Recommendation Report for Planning Permission for Works or Extension to a Dwelling

REF NO: P/108/20/HH

LOCATION: 32 East Front Road
Pagham
PO21 4SU

PROPOSAL: Single storey rear extension including demolition of existing conservatory. 8 x rooflights and alterations to roof over front bedroom from gable to flat roof and conversion of central roof from hip to gable end with alteration to fenestration

Rev	Revision	Date
PROJECT		
32 East Front Road, Pagham		
TITLE		
Proposed Site Plan		
DRAWING No. P0009	SCALE (@A1) 1 : 50	Project Ref: J20025
THE EMARRA COMPANY		
www.emarra.co.uk Tel: 07803 924465 Email: info@emarra.co.uk

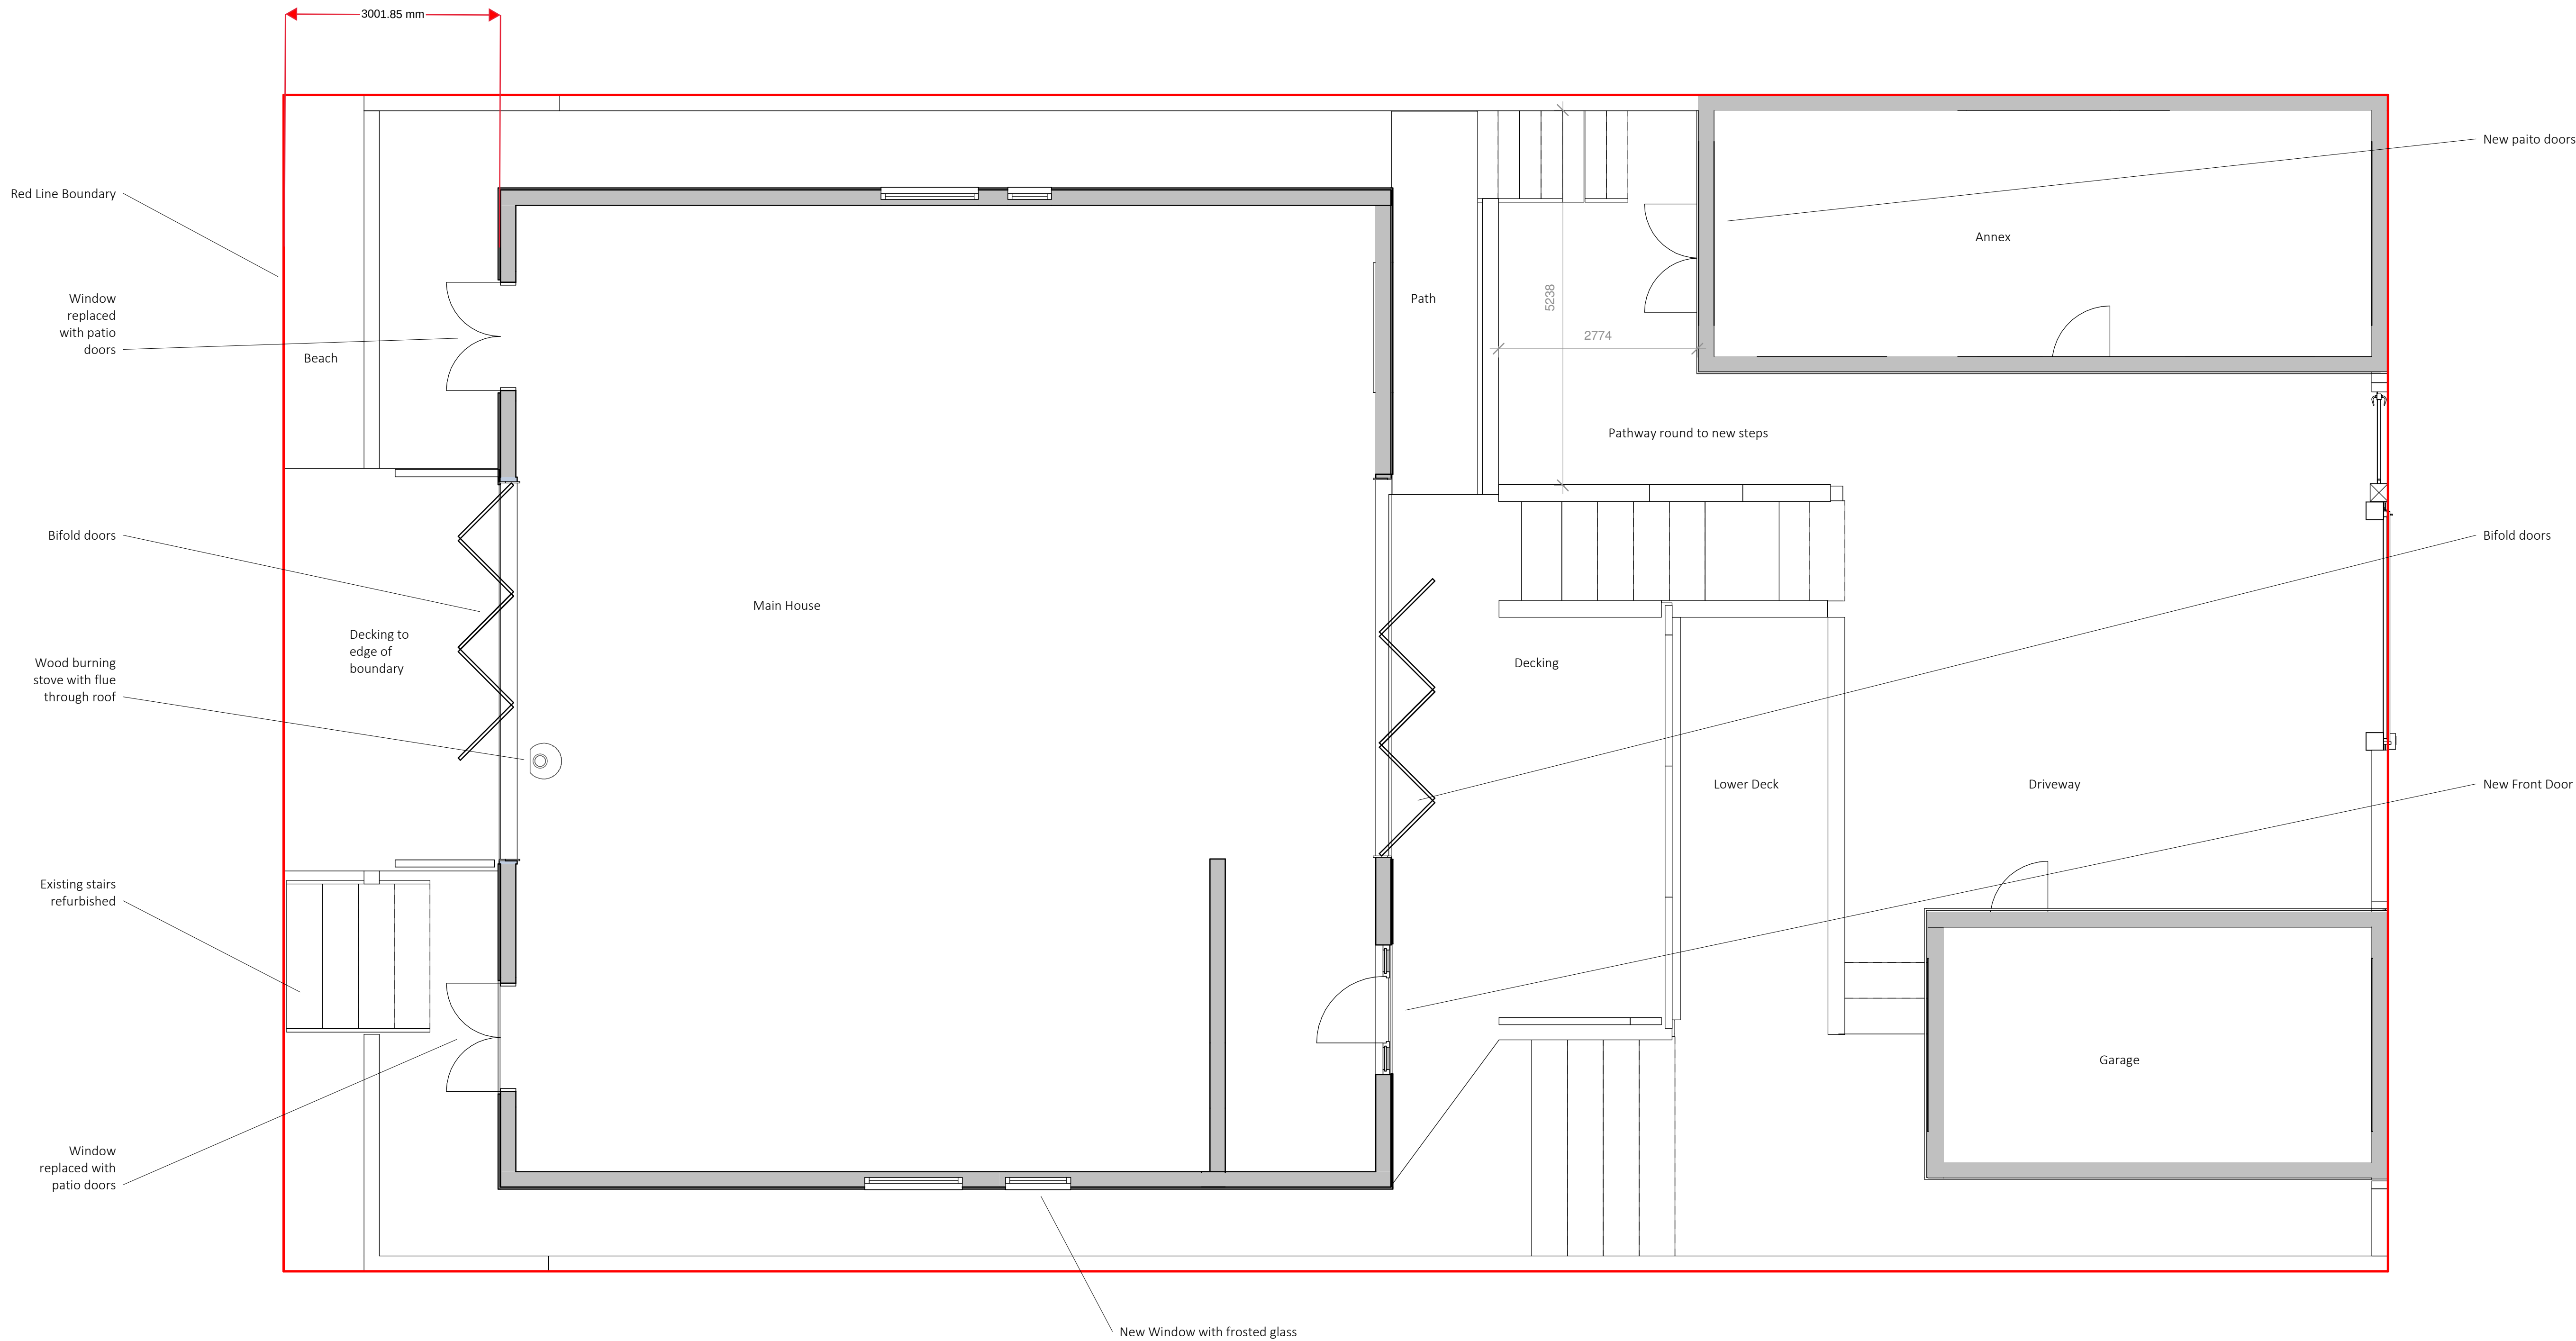
- The application form in completed incorrectly.
- The site boundary is misinterpreted. showing an area of upper beach within the site and within the companys land.
- The boundary is formed by the retaining wall.
- It appears to remove a section of retaining wall.
- A more robust FRA should be submitted.

- There are no apparent errors in the application form with certificate B signed confirming notice has been given to relevant owners.
- The wall is retained with the decking extending above.
- The Environment Agency have been consulted.
- The agent has been contacted with regards to the ownership and has provided confirmation they believe the submission is correct. The issue regarding land ownership would be a private matter.

A	Section created	14 Dec 2020
Rev	Revision	Date
PROJECT		
32 East Front Road, Pagham		
TITLE		
Section		
DRAWING No.	SCALE (@A1)	Project Ref:
P0010	1 : 25	J20025
THE EMARRA COMPANY		
www.emarra.co.uk Tel: 07803 924465 Email: info@emarra.co.uk

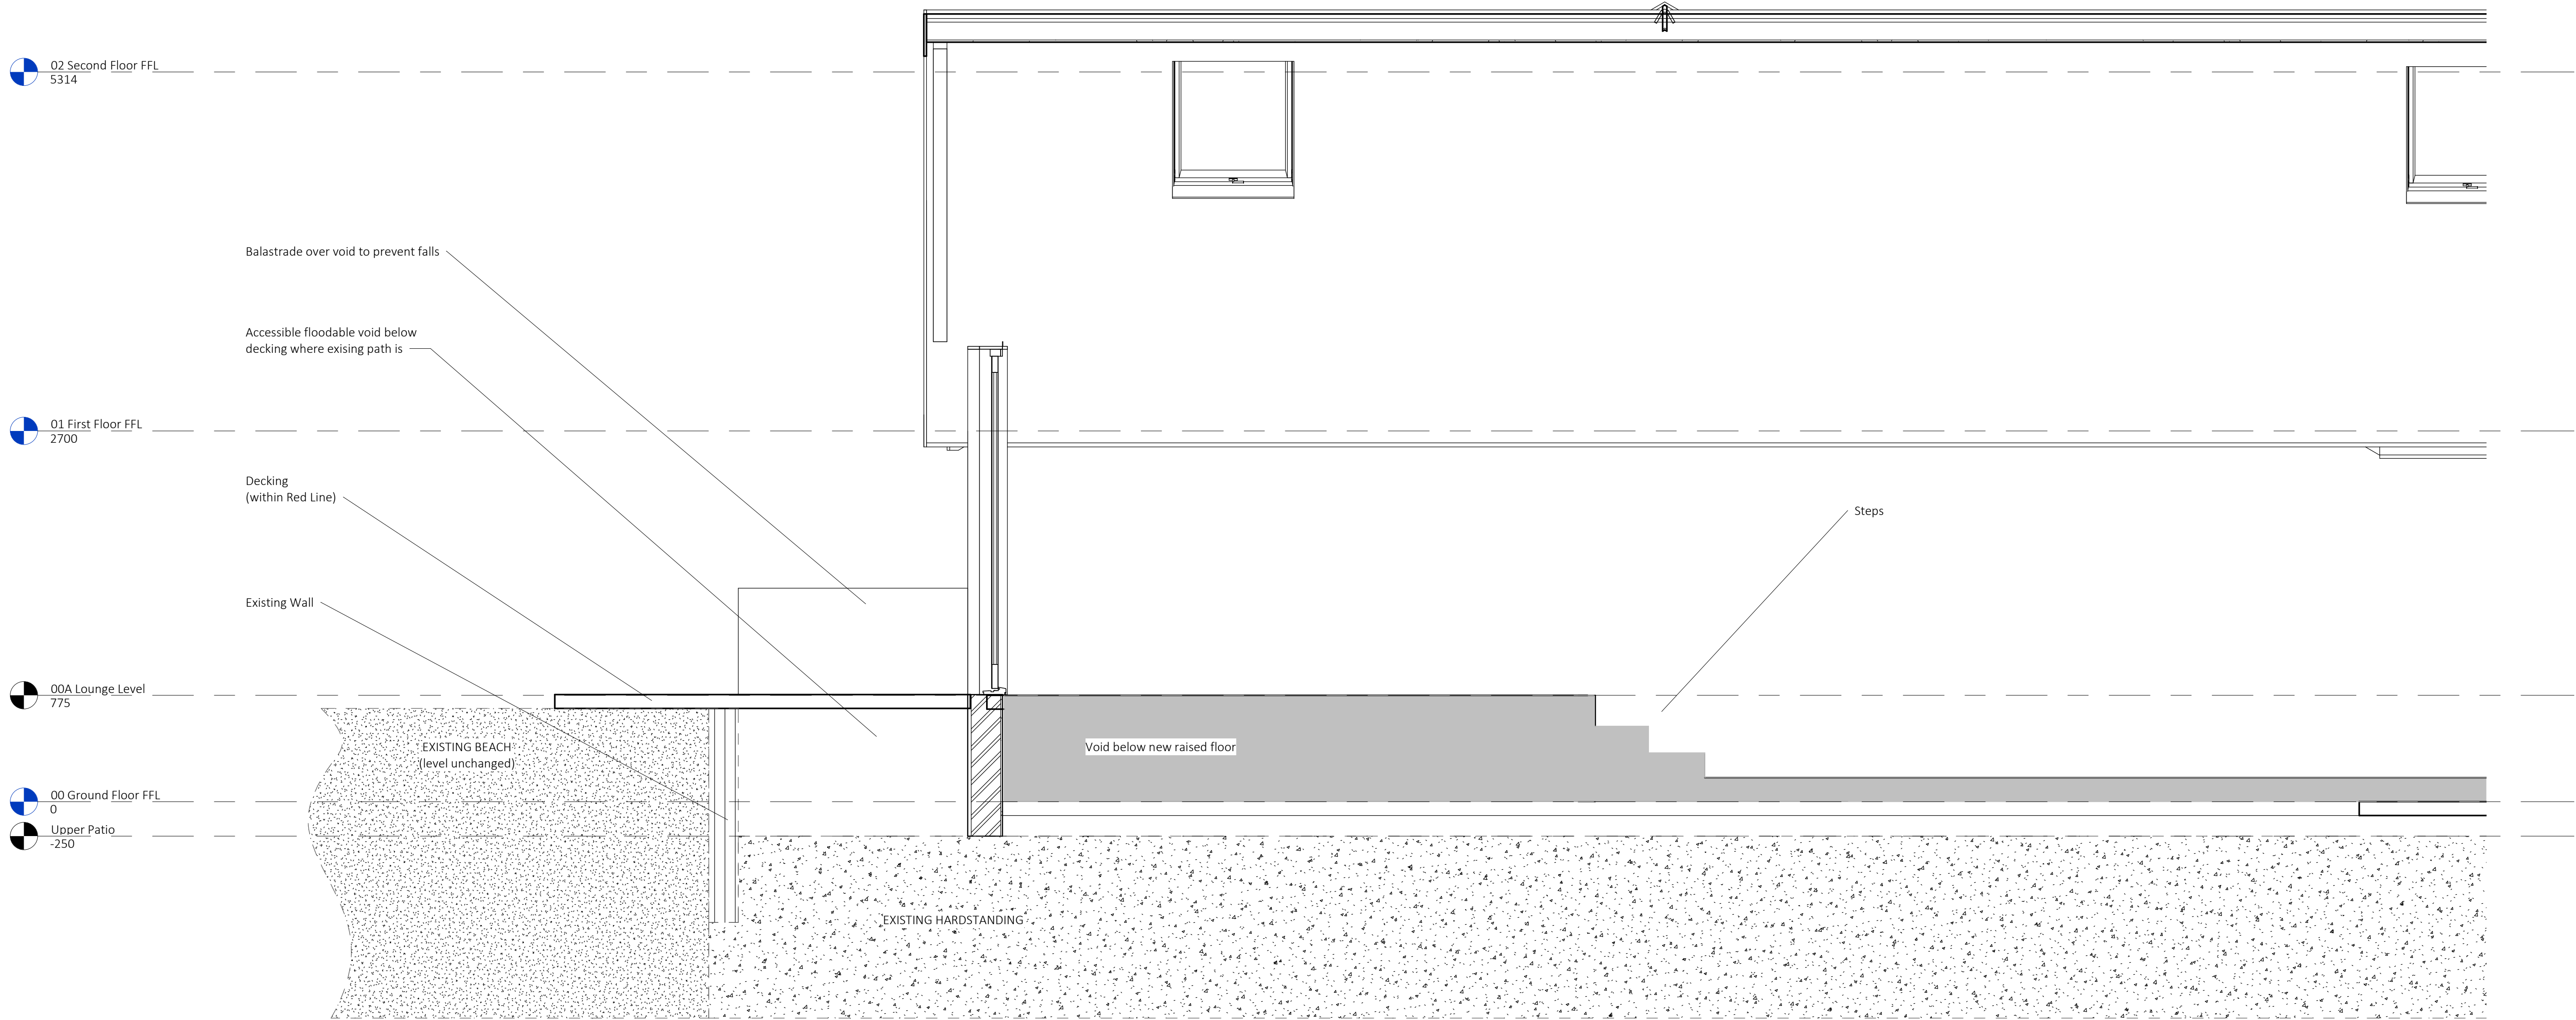
To the rear, the internal floor level will be raised in part of the house. Doors will then lead out onto a raised decking area extending over an existing retaining wall. This is around 0.75m off the ground. As such there will be a balustrade to the side elevations for safety.
